ENGINEERING SITE PLAN FOR EXCEL TELECOMMUNICATIONS SERVICE CENTER

MEMORANDUM

Date: January 2, 1996
To: Lynn Chandler, Building official
From: Stade Strickland, Director
Subject: Excel Telecommunications, Inc.

Drawing file: 16675 Excel Telecommunications Service Center 1195 / 4of12 SP.pdf

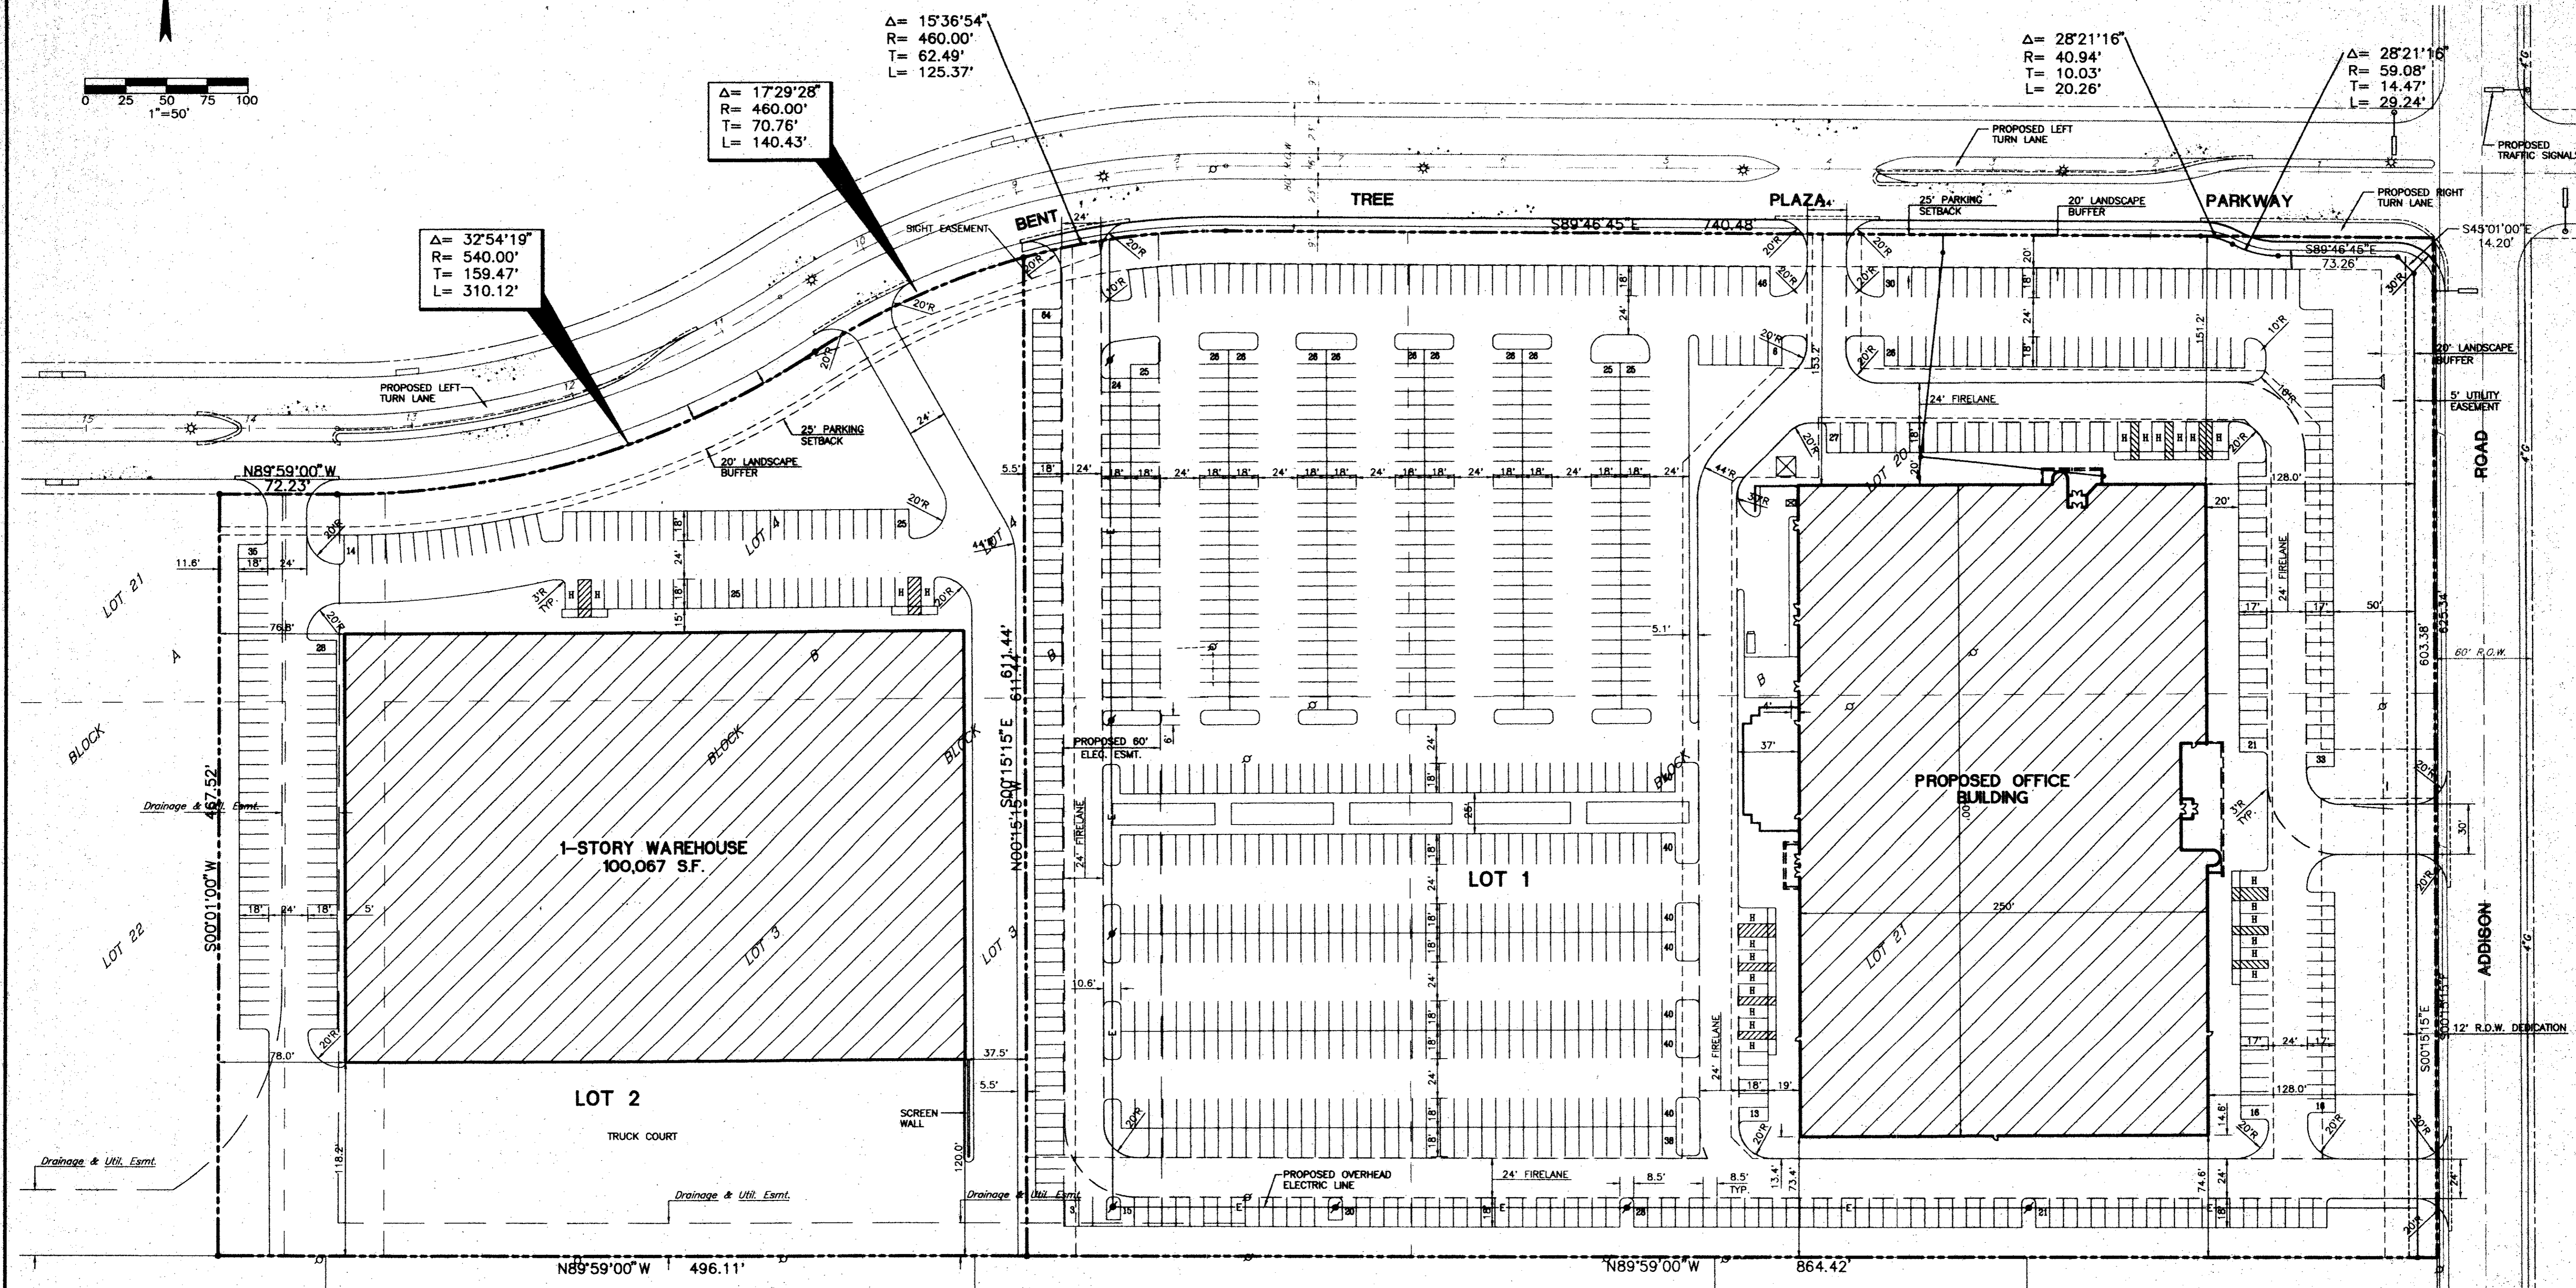
- Specify which type of grass is proposed and whether it will be sodded or seeded. Sodding is preferable;
- Add 21 shade trees to comply with the number of trees required by the landscape ordinance;
- Move all shade trees outside of the dedicated roadway area along Addison Road;
- Show a 5 feet wide sidewalk along Addison Road.
- Show benning along Addison Road and Bent Tree Plaza Parkway

The detention area shown along Addison Road is inconsistent with the intent of the landscape ordinance because it provides no visual buffering of the building and the parking lot. It needs to be located to the south or west side of the site behind the building so it can't be seen from the street.
